WEST SUSSEX COUNTY COUNCIL CONSULTATION

TO:	Arun District Council FAO: Maria Tomalova
FROM:	WSCC - Highways Authority
DATE:	18 September 2020
LOCATION:	116 Nyetimber Lane Bognor Regis PO21 3HL
SUBJECT:	AW/170/20/HH Dropped kerb.
DATE OF SITE VISIT:	n/a
RECOMMENDATION:	Advice
S106 CONTRIBUTION TOTAL:	n/a

116, Nyetimber Lane, Aldwick, West Sussex, PO21 3HL

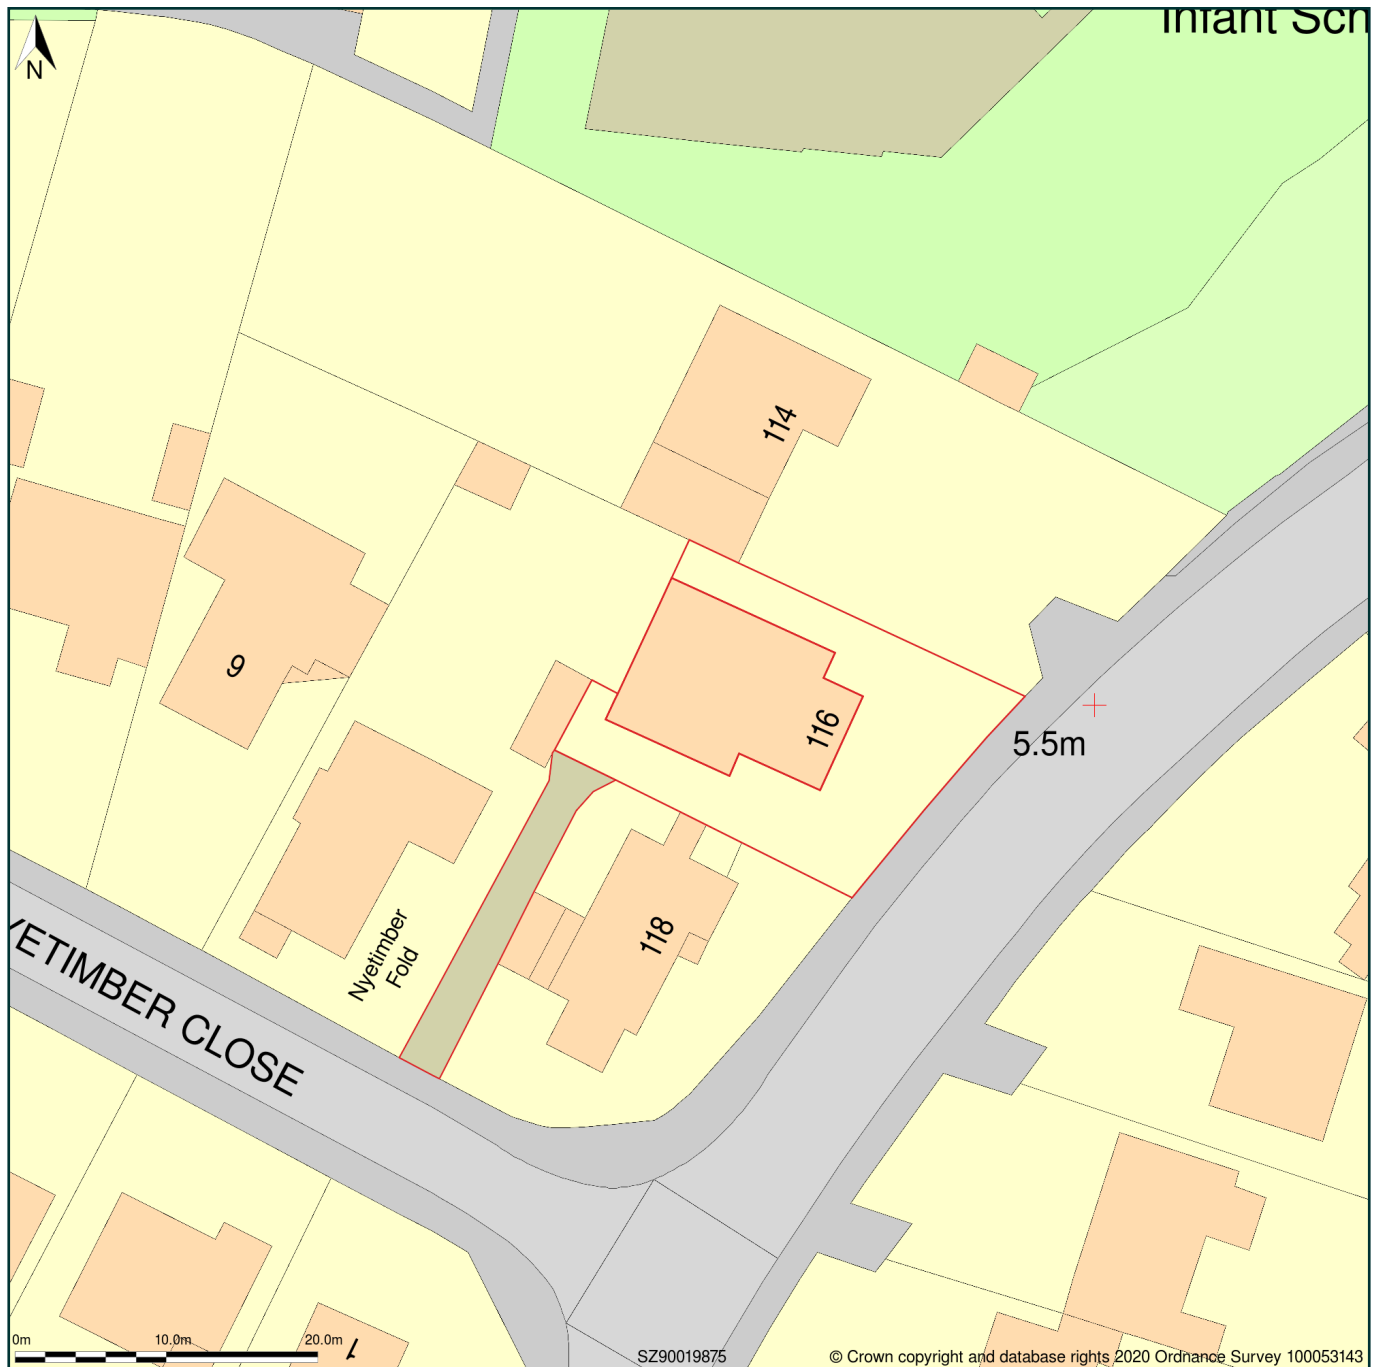
The applicant proposes to implement a 5.5 metre VCO at this location. This conforms to the maximum VCO guidance of 6.4 metres laid out in WSCC guidance.

From an inspection of WSCC and local mapping and the submitted plans demonstrating visibility of 2.4 x 43 metres in both directions, visibility upon along Nyetimber Lane is enough with excess of 2.4m by 43m available from the centre of the proposed access point, within maintainable highway land. Manual for Streets sets out that 43m is suitable stopping sight distance (SSD) for vehicle speeds of 30 mph and therefore the LHA do not raise concerns regards the proposed location of the access point.

The use of the access shall not commence until visibility splays of 2.4 x 43 metres in both directions have been provided at the proposed site vehicular access onto Nyetimber Lane in accordance with plans and details submitted to the Local Planning Authority. The splays shall be maintained and kept free of all obstructions over a height of 0.6 metre above adjoining carriageway level or as otherwise agreed.

The use of the parking area shall not commence until the vehicular access serving the development has been constructed in accordance with the approved site plan.
